From: Martin Hill <Martin.Hill@arun.gov.uk>
Sent: 18 May 2021 17:47
To: Planning.Responses <Planning.Responses@arun.gov.uk>
Subject: RE: Planning Consultation on: BR/301/20/PL

Comments from Private Sector Housing:

Application No: BR/301/20/PL
Registered: 29th April 2021
Site Address: 2 London Road Bognor Regis PO21 1QU
Grid Reference: 493637 99083
Description of Works: Alteration, conversion and partial demolition of existing building including the addition of 2nd floor extension to form 3 No one bed apartments with associated refuse & cycle storage. This site is in CIL Zone 4 (Zero Rated) as flats.

Drawing Title:
Proposed Floor Plans

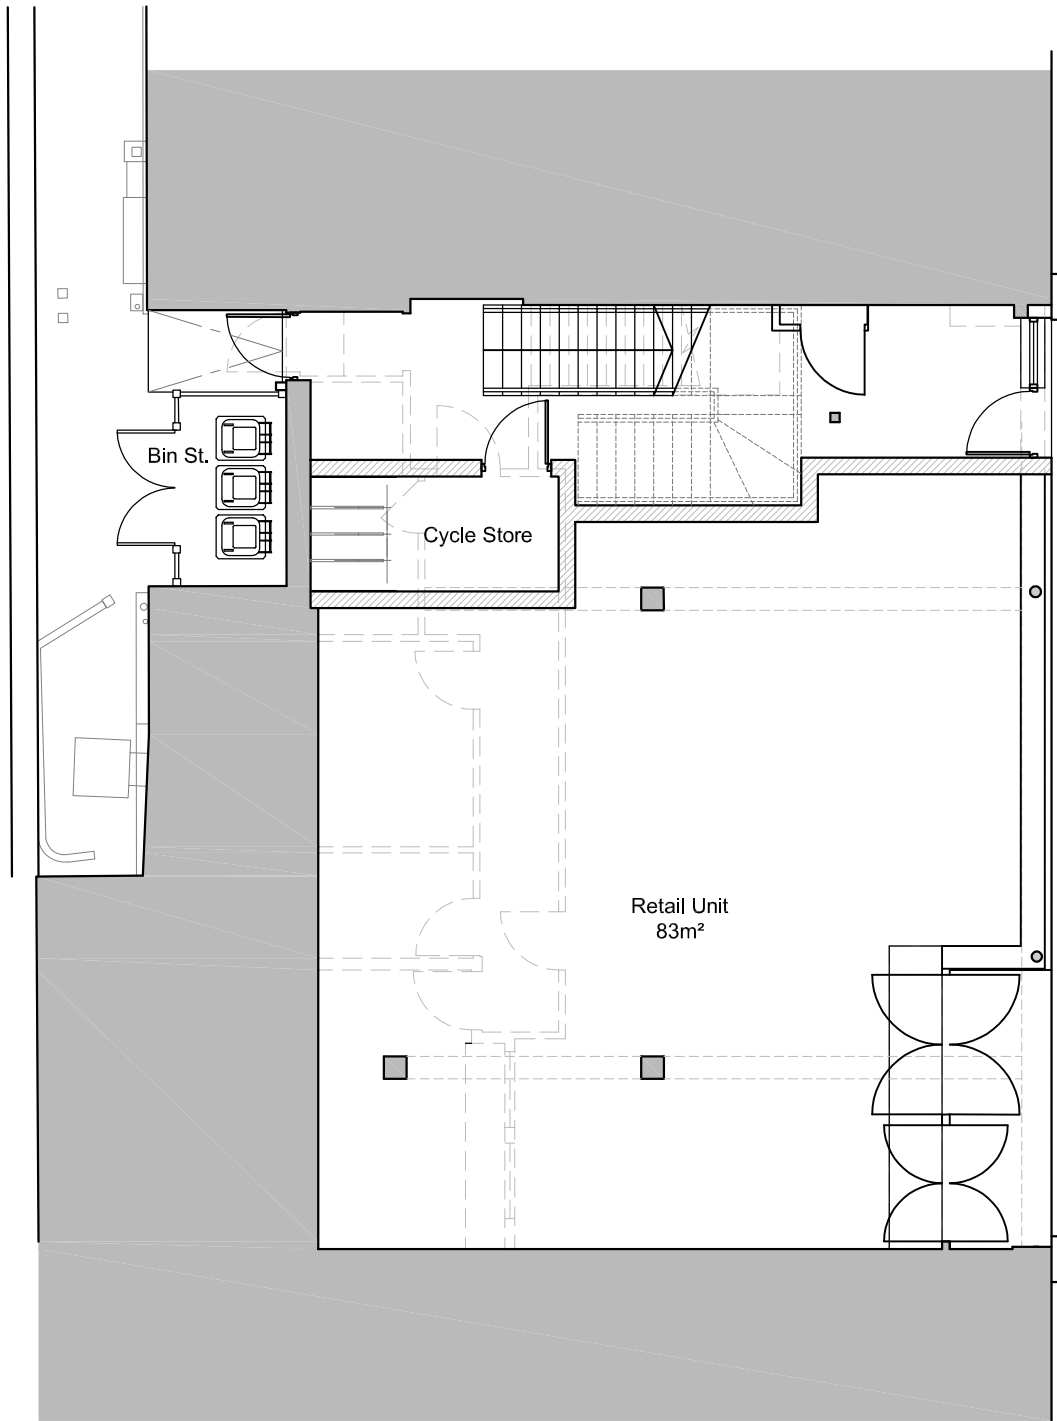
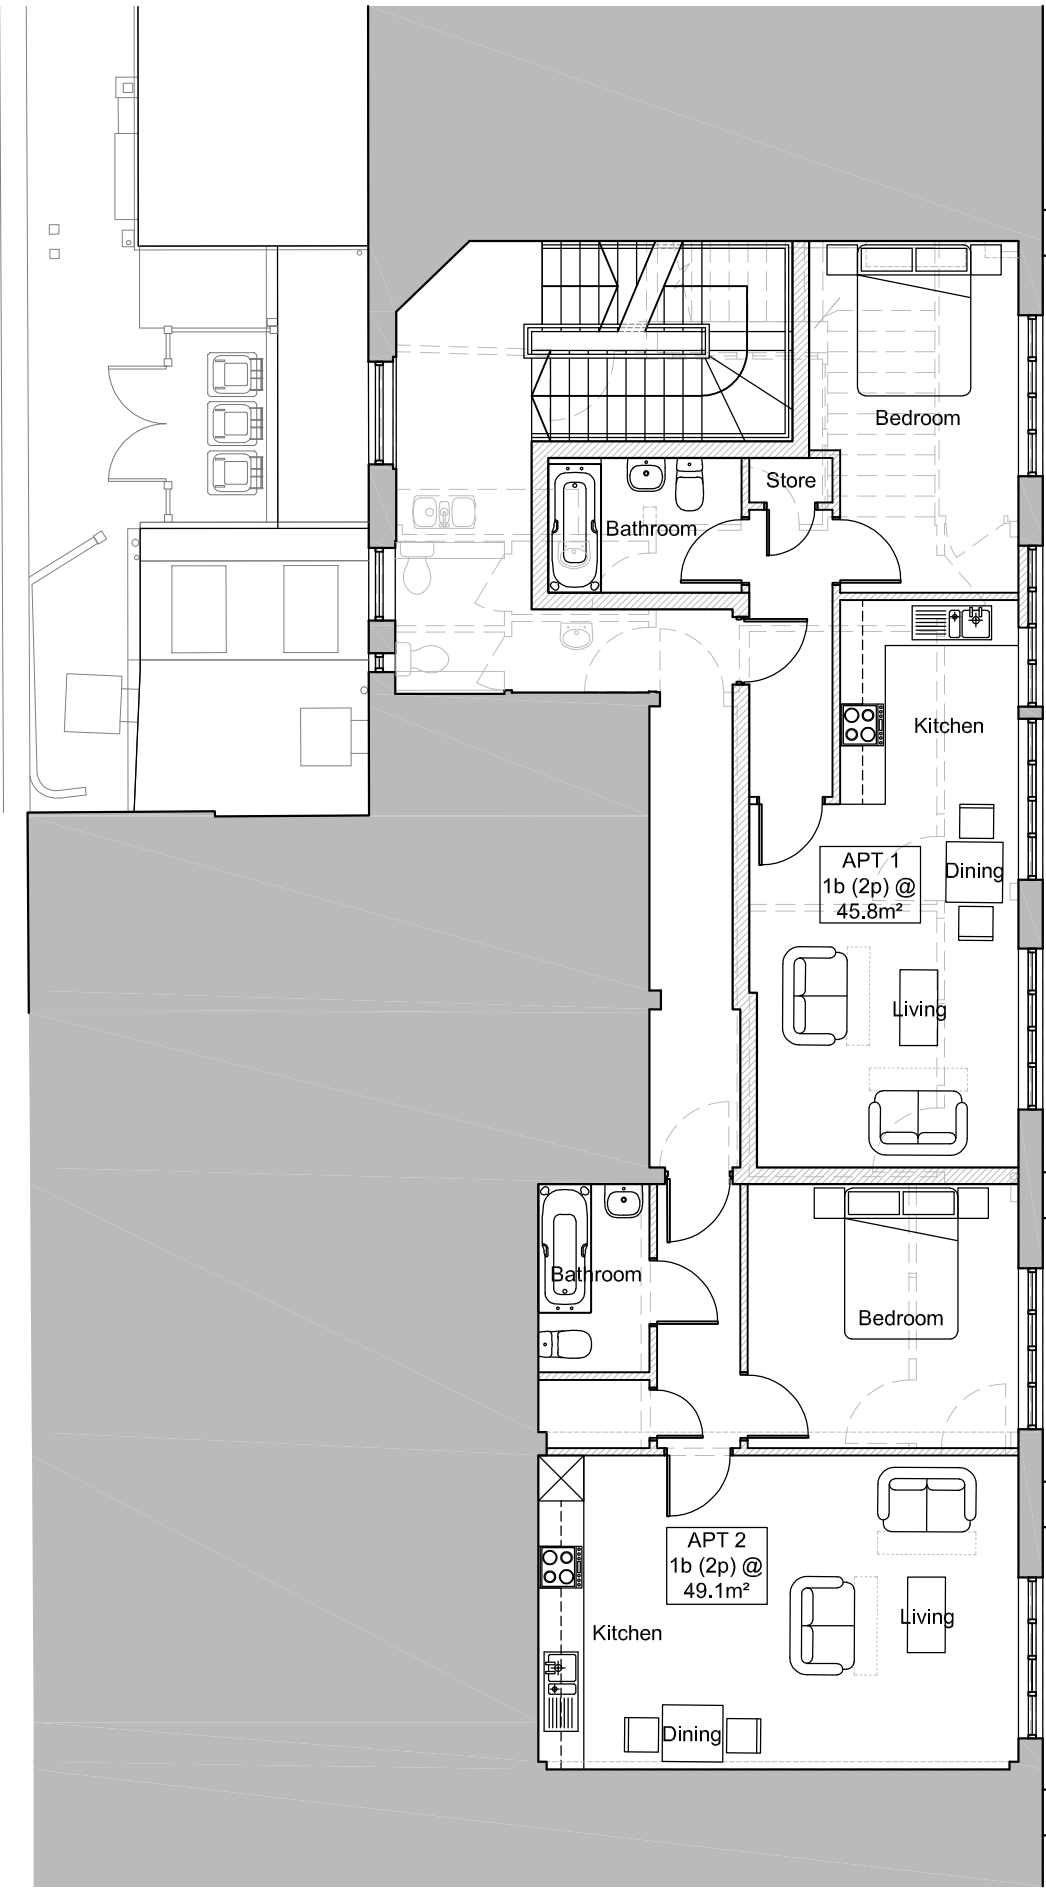
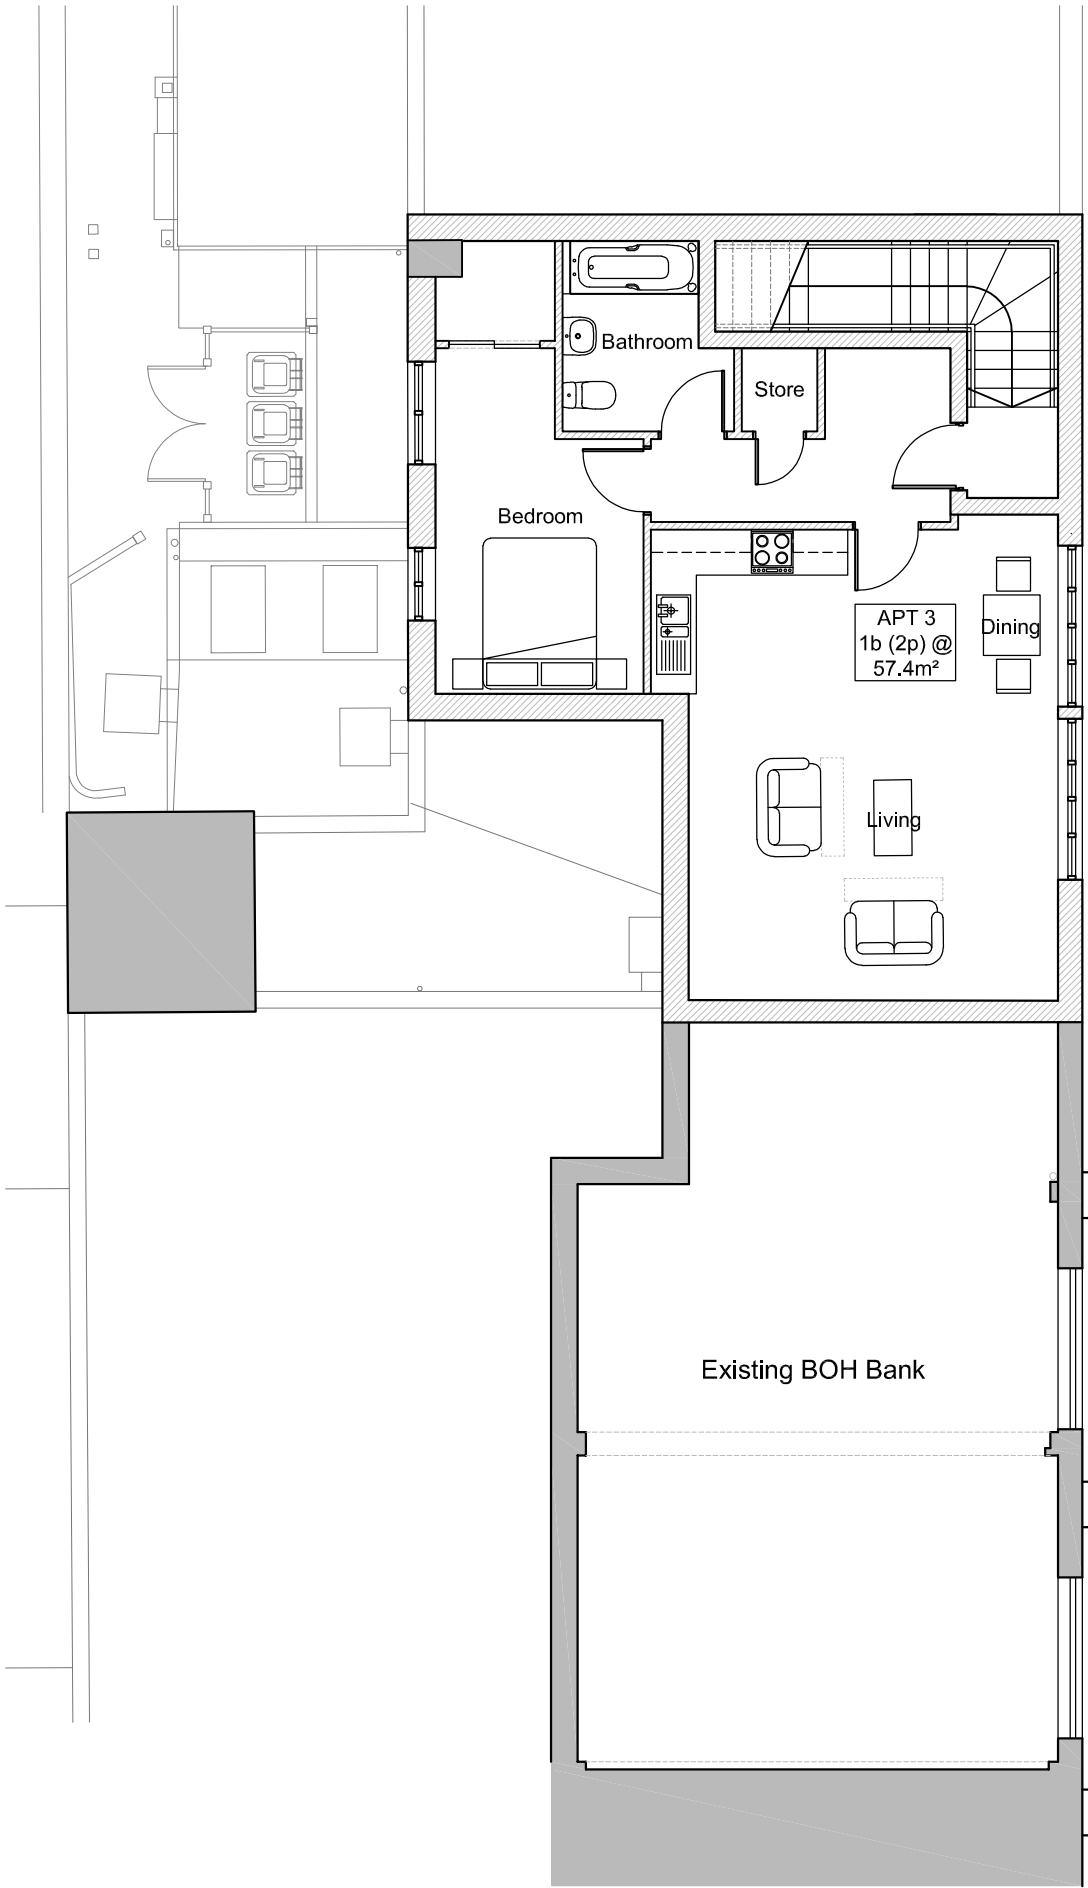
- There should be adequate fire separation between the commercial unit on the ground floor and the residential flats above. If 60 minutes fire separation cannot be achieved, there must be a system of interlinked fire alarms and detection serving both the commercial and residential areas.

- 30 minute fire resisting escape route, which would include providing a 30 minute fire resisting and self-closing fire door (FD30S standard) to the entrance of each flat and proposed cycle store.

- The area in the north-east access point (opposite side to bin store area) must provide for a minimum 30 minutes fire resistance to protect the means of escape stair and any enclosures such as service cupboards must be enclosed in a minimum 30 minute fire rated enclosure. If this area is connected to the commercial area on the ground floor, this must afford a minimum 60 minutes fire resisting separation to the residential area, or if this cannot be achieved, the interlinked smoke detection system must extend to this area to provide early warning to the floors above.

- Install an FD30S fire door to separate the first floor corridor from the escape stairs, in order to add further protection to the single means of escape and provide an area of relative safety in the event of a fire in one of the flats.

- The bin storage area should ideally be located approximately 6 metres away from the building, however if it is to be located in the proposed position it should be enclosed in a

minimum 60 minute fire resisting enclosure due to the proximity to the access/egress point of the property.

- Grade A, LD2 fire alarm and detection system consisting of,
 - o interlinked mains wired smoke alarm and detection located throughout the escape route, in the communal bin storage area and in the cycle storage area.

- o Interlinked heat detection to be located in the entrance hall/lobby of each flat.
Please note that the applicant should seek the advice from a Fire Risk Assessor and West Sussex Fire & Rescue Service as to the appropriate level of fire alarm and detection system, including the most appropriate detection type for the bin storage area (heat or smoke detection). Where an interlinked fire alarm and detection system exists between commercial and domestic, there should be access available to the control panel for attending emergency crews and persons having control.
